Address: 133 River Edge Dr.
(Lot 15 - River Edge)

C-B-L: 229-A-045
permit # 2014-01956

CHECK-LIST FOR ZONING COMPLIANCE - PRUDS

Proposed Work/Use: build two story, single family w/ attached 3 car garage
48' x 30' (main house)
41.5 x 26 (garage)

**SITE PLAN**  
 133 RIVERS EDGE DRIVE  
 PORTLAND, ME

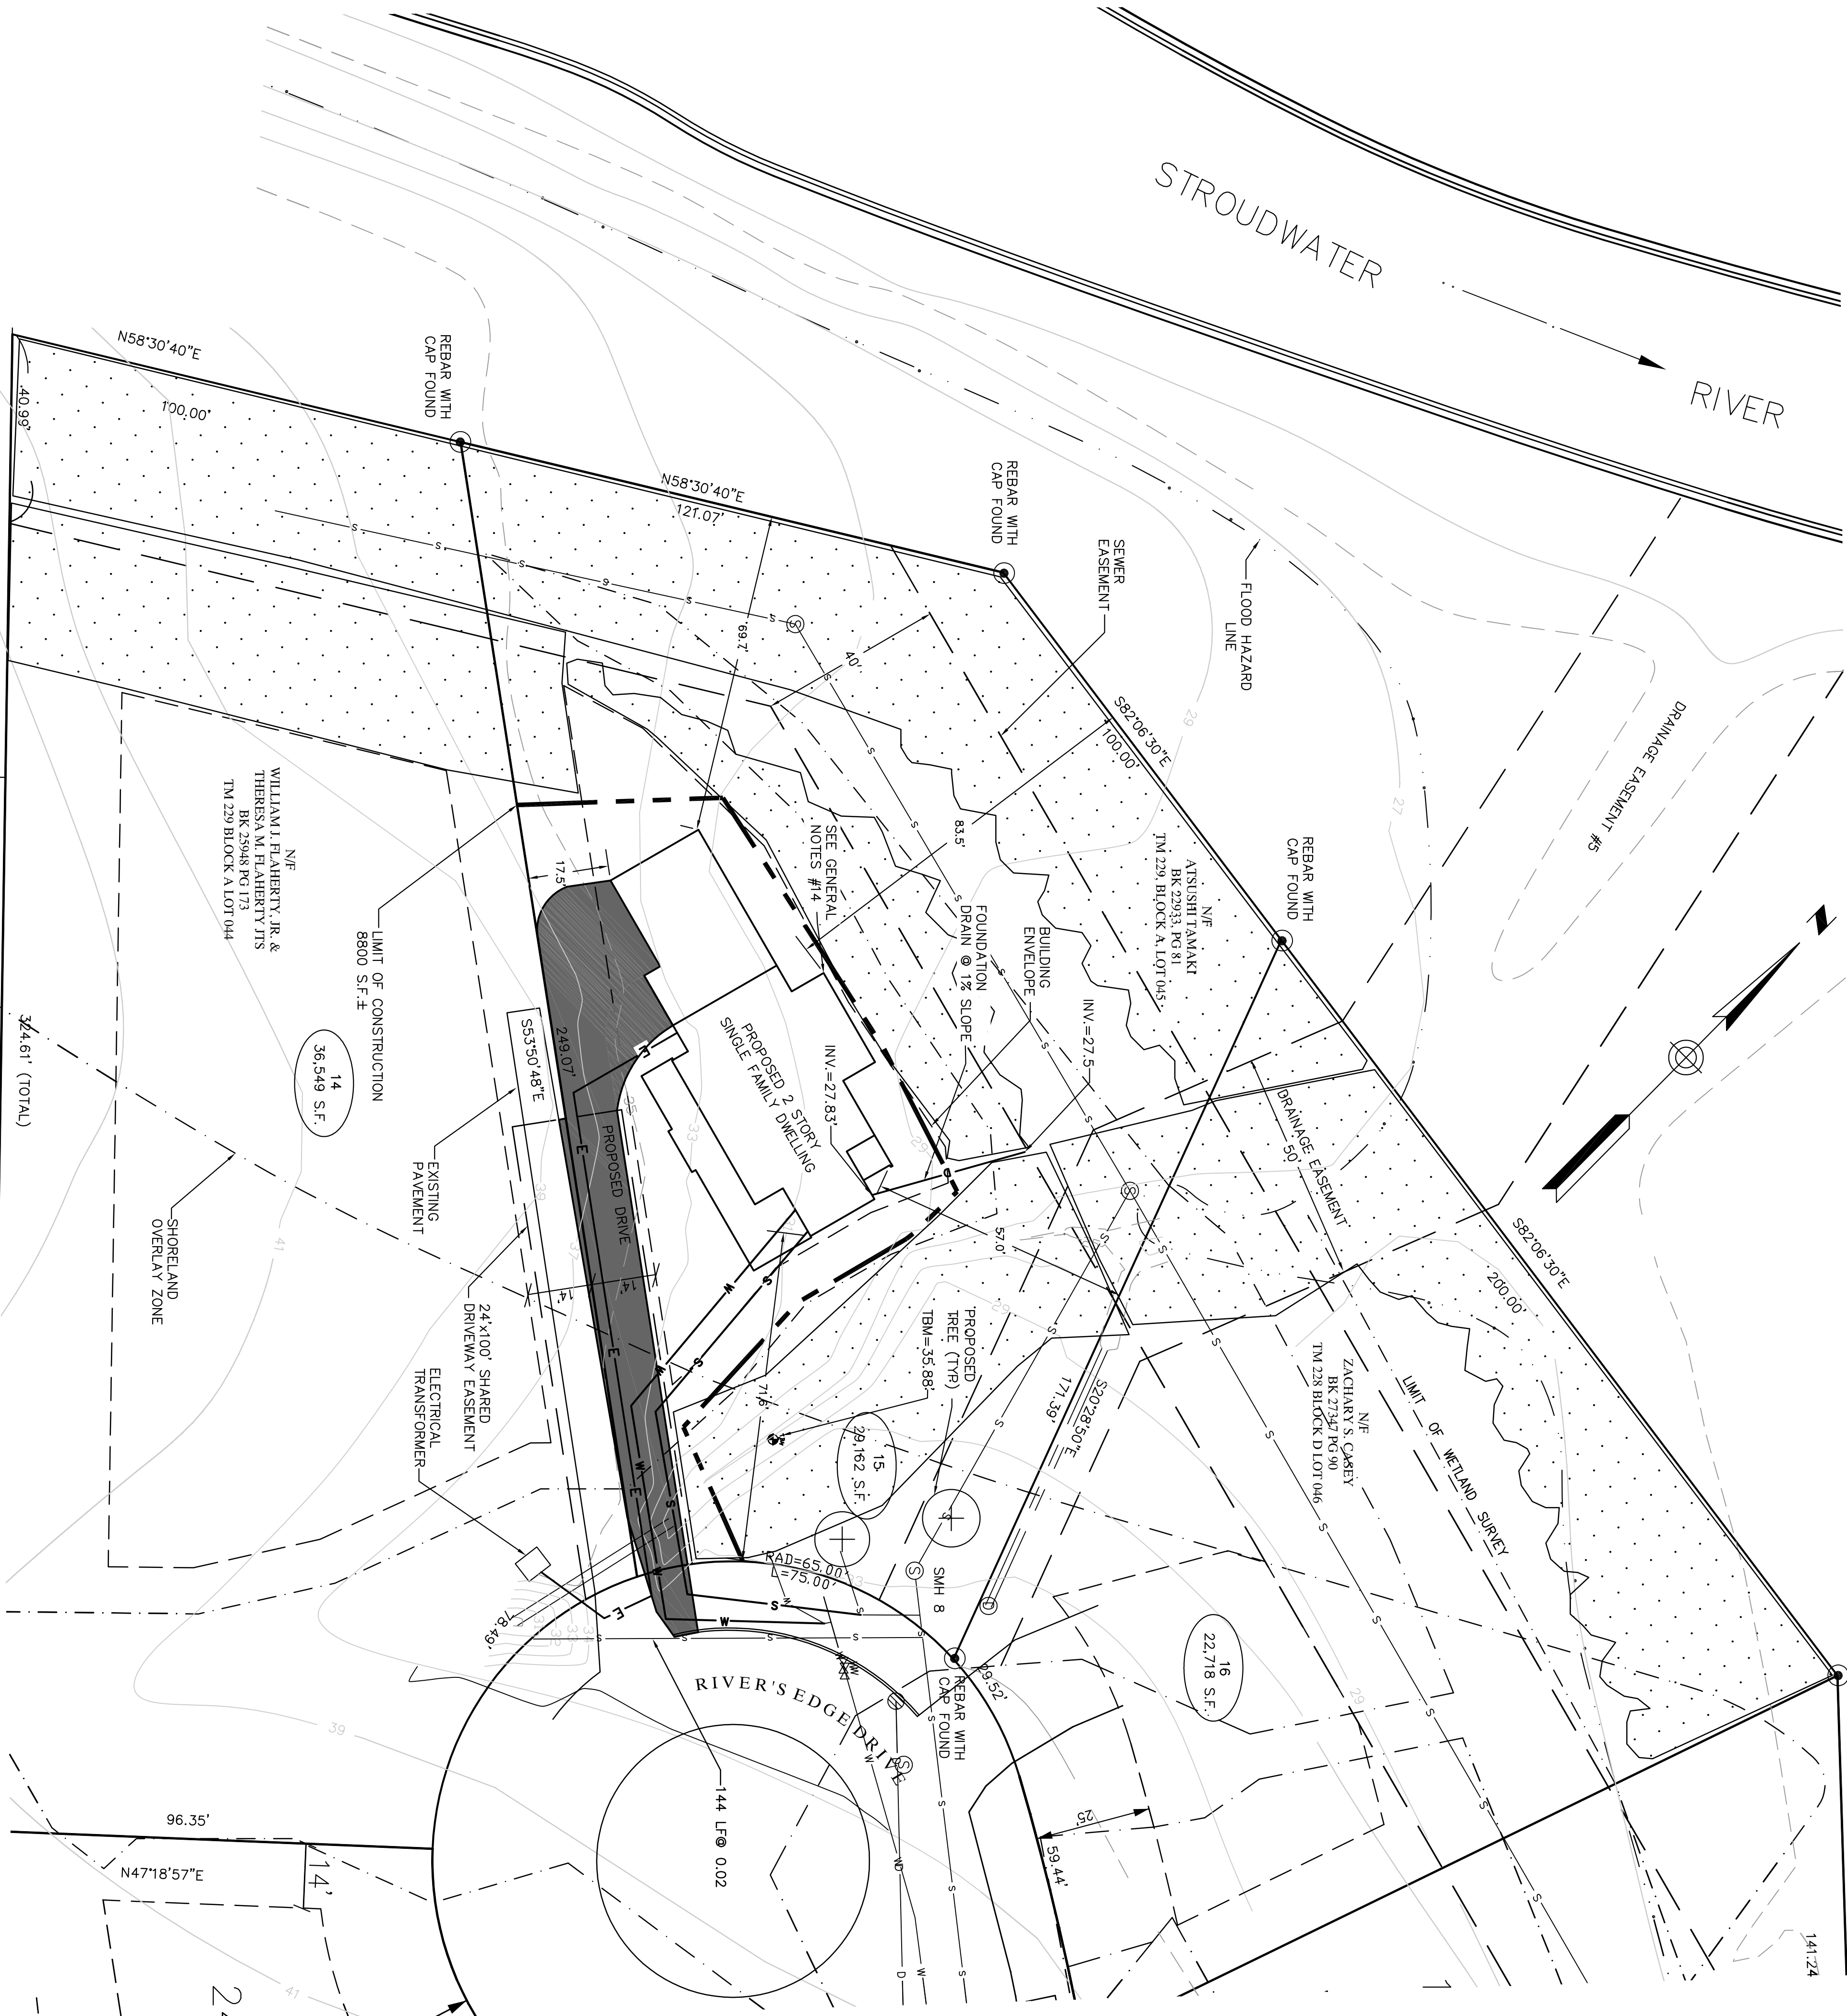
Street Frontage: 50' min. - 75' given (OK)

Max. Height: 35' max - 33.55' to lowest grade in rear from ridge (OK)
- 29.64' to top of ridge - (OK)

Min. Setbacks from External Subdivision Property Lines: - 25' (3 or less units) - 71.25 scaled

Min. Distance Between Detached PRUD Buildings: - 16' OK - 17.62' to property line w/ lot 14
- 58.1' to " " w/ lot 16

Net Land Area Per Dwelling Unit: 6500 sq ft - 29,162 sq ft (OK)

Shoreland/Stream Protection: property w/in 250' setback - but 75' from 75' setback

Flood Plain: Panel 12 - zone X - top right corner zone X 500 year flood

* shared driveway w/ lot 14
